Medworth Energy from Waste Combined Heat and Power Facility

PINS ref. EN010110
Document Reference Vol.15.6a
Revision: 1.0
Deadline: 6
July 2023

Applicant's comments on the Deadline 5 Submissions: Part 1 Statutory Parties

**Figure 10.1iv**  
**Cromwell Road/New Bridge Lane Signal Scheme - General arrangement**

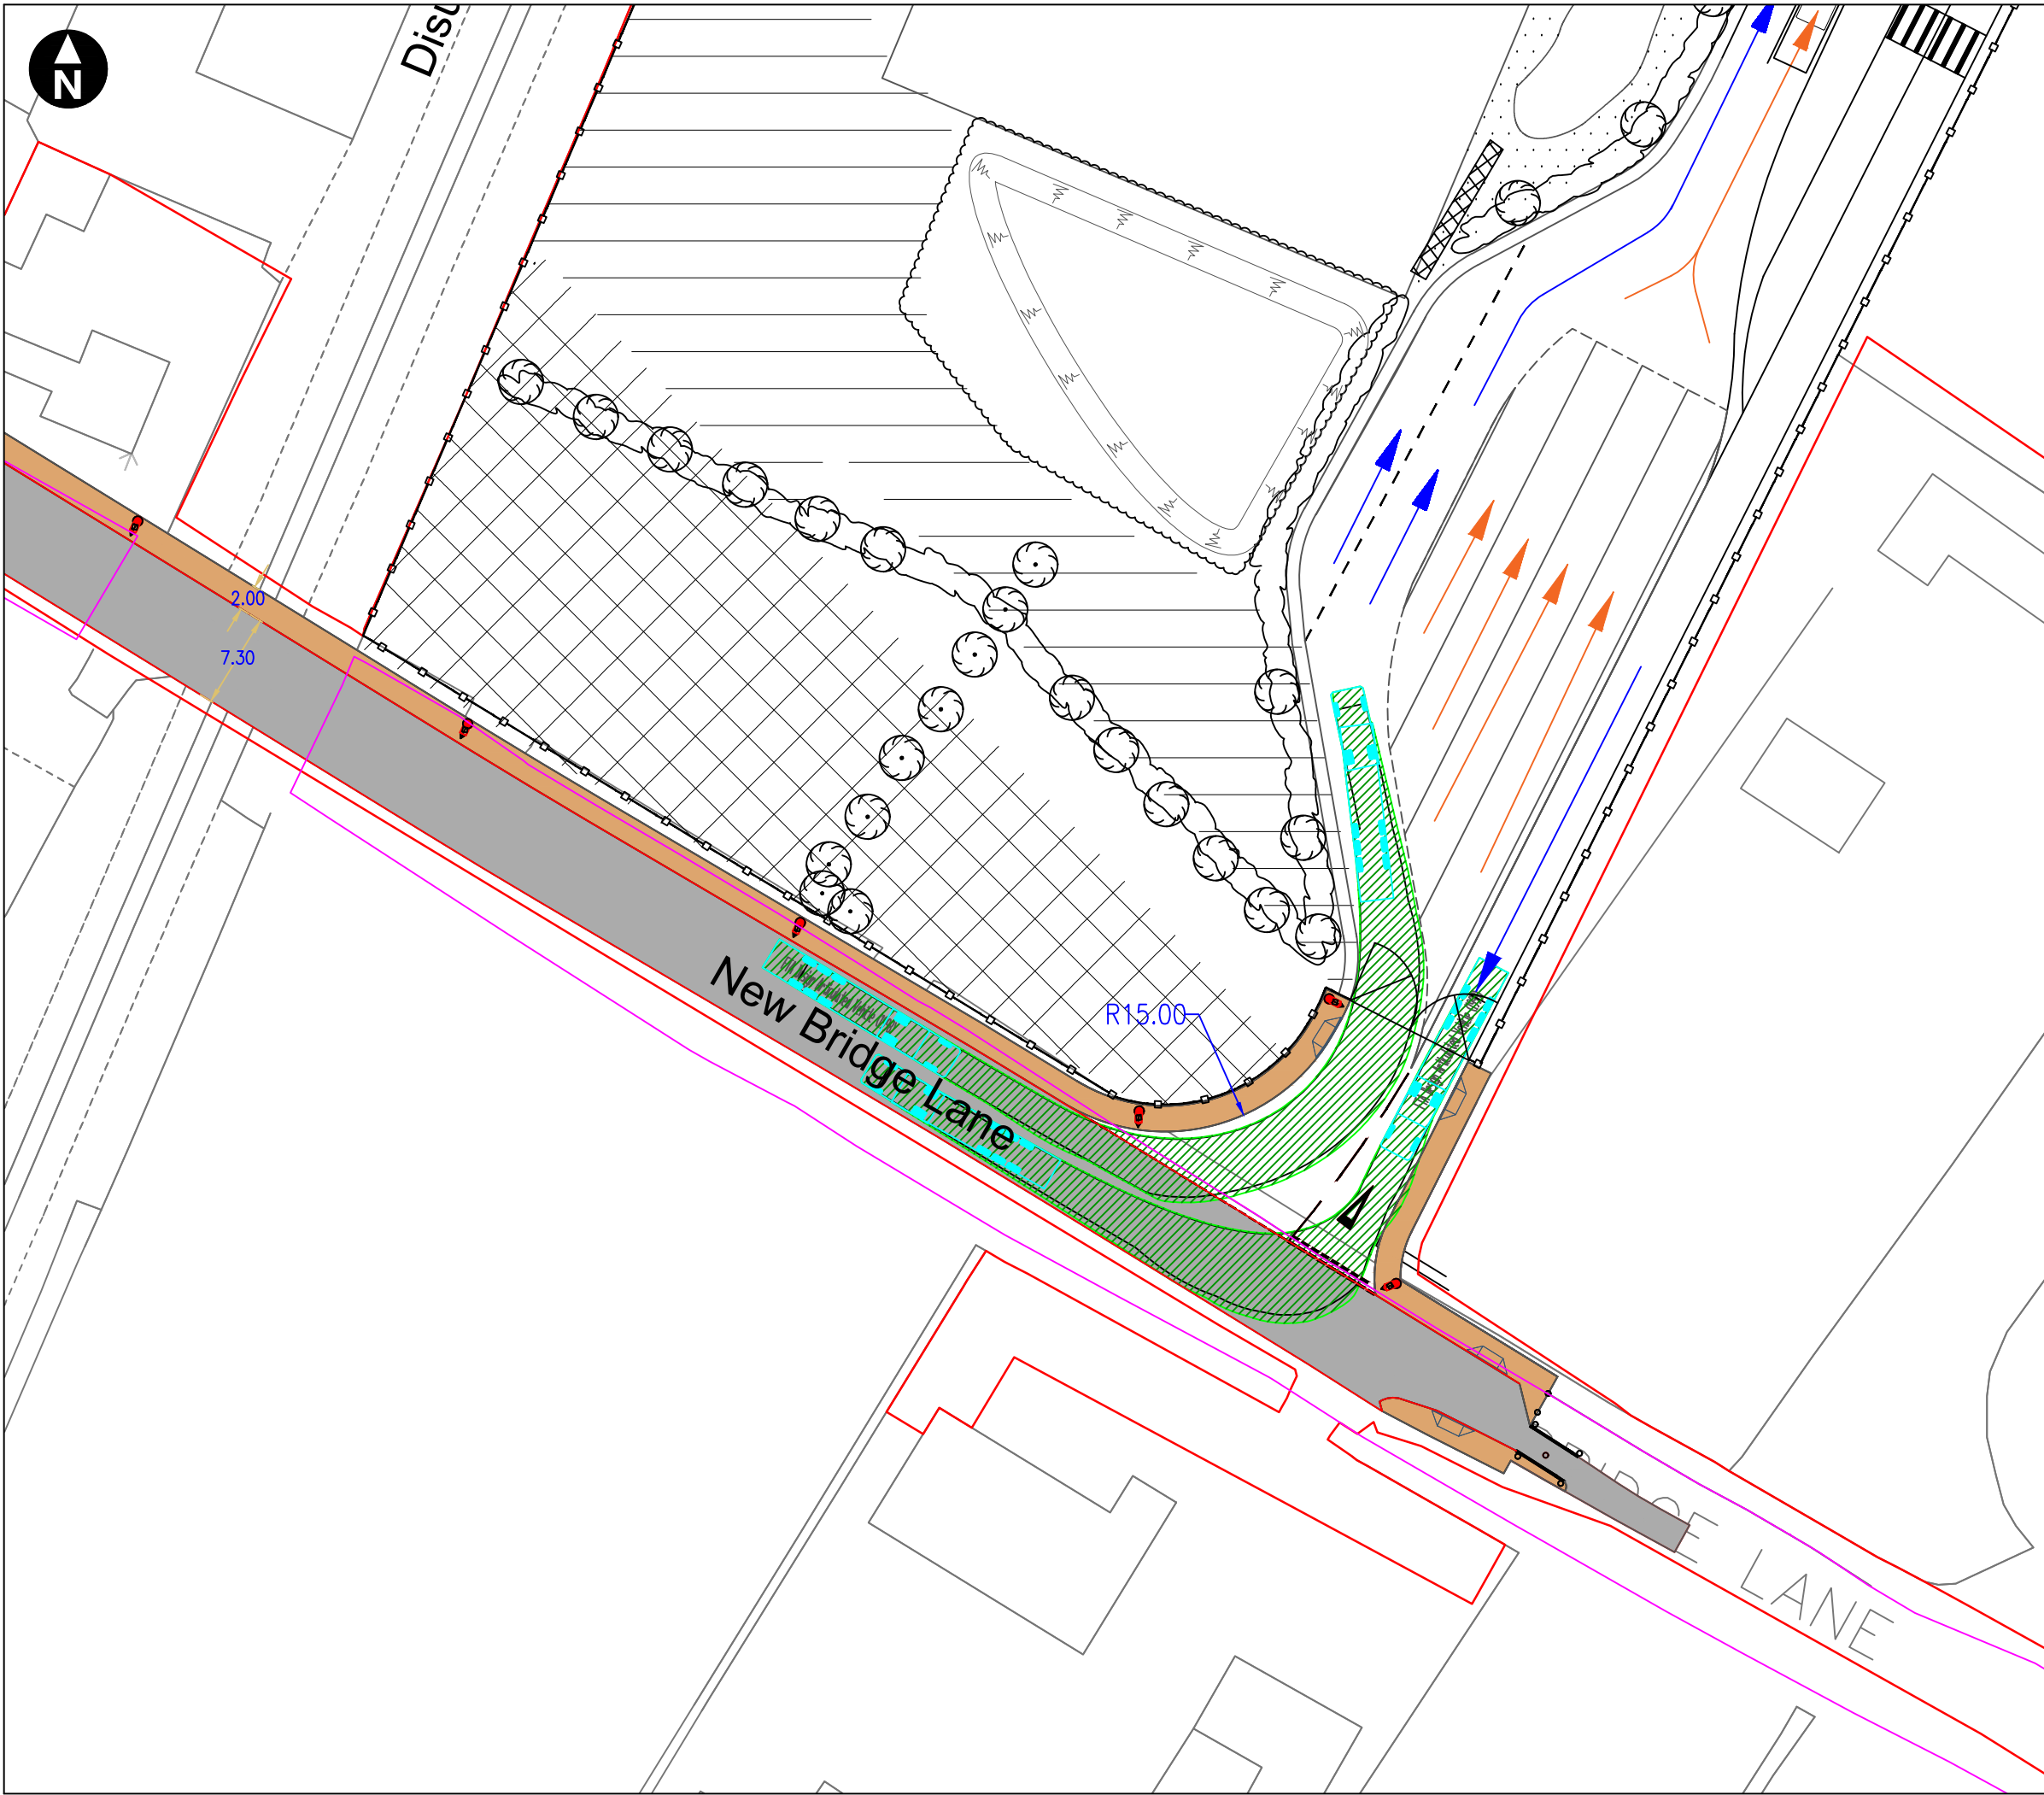
ID	Topic/Para	CCC/FDC Response	Applicant Comment
		<p>its position with regard to the content of the application for a non-material amendment. • Improvements to the Cromwell Road / New Bridge Lane Junction, specifically CCC's requirement that the junction design incorporates full signalisation.</p> <p>CCC is continuing its discussions regarding the above matters with the Applicant. Drawings and traffic modelling relating to the New Bridge Lane Cromwell Road Junction, New Bridge Lane widening and associated works, together with a Stage 1 Road Safety Audit were submitted to CCC on 25 May 2023 by the Applicant, and are continuing to be considered by the CCC at present.</p>	
2	<p>Action Point 3</p> <p>Applicant to work with CCC on negotiations of Section 208 Agreement, particularly financial contributions to the maintenance of roads.</p>	<p>The Applicant provided CCC with a draft S106 heads of terms on 13 June 2023. CCC are currently reviewing the proposed head of terms and will provide feedback to the Applicant accordingly. Discussions are ongoing about the inclusion of further matters in the S106. In relation to a Section 278 Agreement, discussions are still ongoing.</p>	<p>Agreed Draft Heads of Terms (Volume 15.8) have been submitted at Deadline 6 and the Applicant's and CCC's respective solicitors are negotiating the draft Section 106 Agreement. The Applicant is confident that the agreements (being the Section 106 Agreement, Section 111 Agreement and Section 278 Agreement) can be completed prior to the end of the Examination.</p>
